DOCUMENT 5.5.2.3

Schedule of Responses to Stakeholder Review of the Draft ES

National Grid (North Wales Connection Project)

Document 5.5.2.3 Appendix 5.3 Schedule of Responses to Stakeholder Review of the Draft ES

Image 4.1 Transposition Process

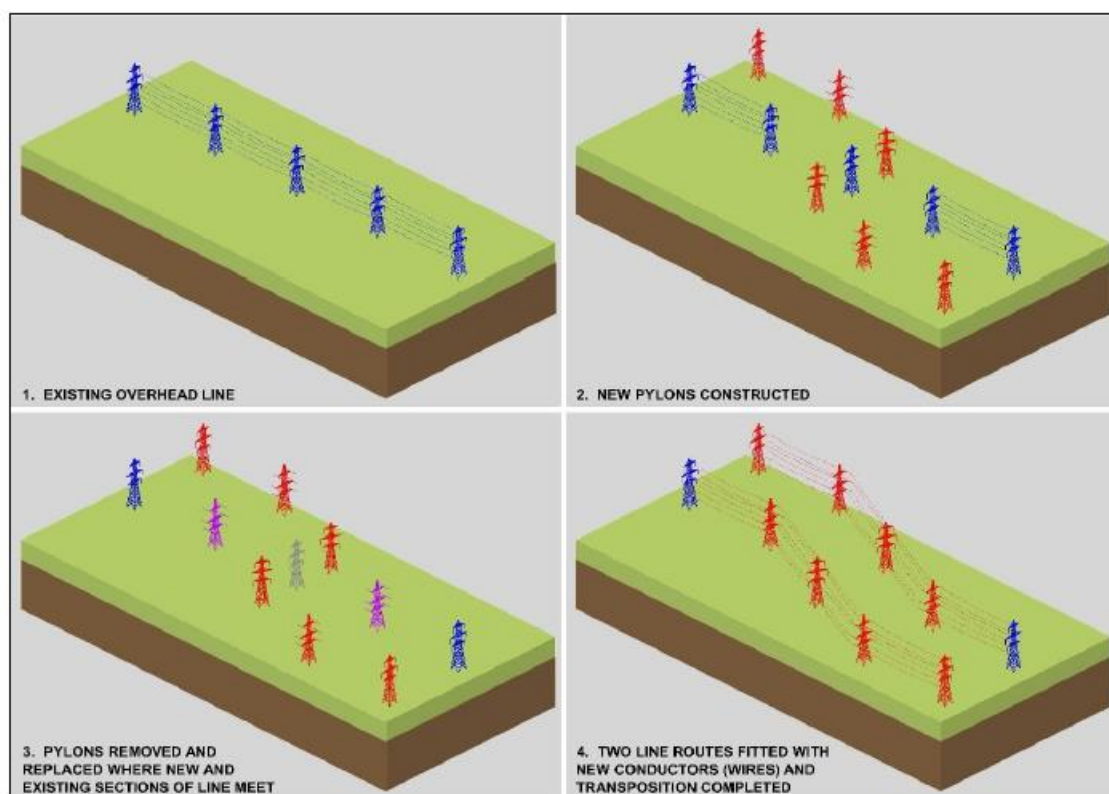
| Table 1: Isle of Anglesey County Council | | | |
|--|--|----------------|--|
| | Transposition - construction As noted at S42 consultation, where the removal of the existing line and construction of new parallel lines to the south of Rhosybol, and between Clorach-fawr and Maenaddwyn, there will be a more intense and prolonged period of construction activity and associated impacts on local residents – this must be clearly defined and assessed within the ES technical chapters alongside a commensurate and tailored mitigation programme. Diagram 3.1 of section 3.3 of the chapter is a useful addition which visually displays the transposition process. | | Impacts on the amenity of local communities are considered in Chapter 17 Socio-Economics (Document 5.17) and its associated appendices, and intra project effects on individual properties are considered in Chapter 19 Intra-Project Effects Assessment (Document 5.19). |
| | Transposition - construction The detail provided with regards to transposition is considered adequate for this chapter, however the construction process must be clearly defined and assessed in the ES technical chapters. | | The construction process of the areas where transpositions would occur is provided in Section 2 of ES Chapter 4 Construction, Operation, Maintenance and Decommissioning of the Proposed Development (Document 5.4). Where transpositions occur it is likely that modifications to the existing 4ZA route infrastructure would be required such as pylon modifications / strengthening, foundation modifications / strengthening or new pylons and conductor bundles. This in turn develops a construction scenario whereby there would be: dismantling works; temporary diversion works; works to the existing 4ZA route; as well as the proposed new build works, all occurring in the same location. Potential effects on local receptors have been assessed in the ES technical chapters. |

| Table 1: Isle of Anglesey County Council | | | |
|--|---|----------------|---|
| | <p>Transposition - construction</p> <p>It is expected that further information will be provided with regards to the construction process in the ES technical chapters.</p> | | The construction process of the areas where transpositions would occur is provided in Section 2 of ES Chapter 4 Construction, Operation, Maintenance and Decommissioning of the Proposed Development (Document 5.4). |
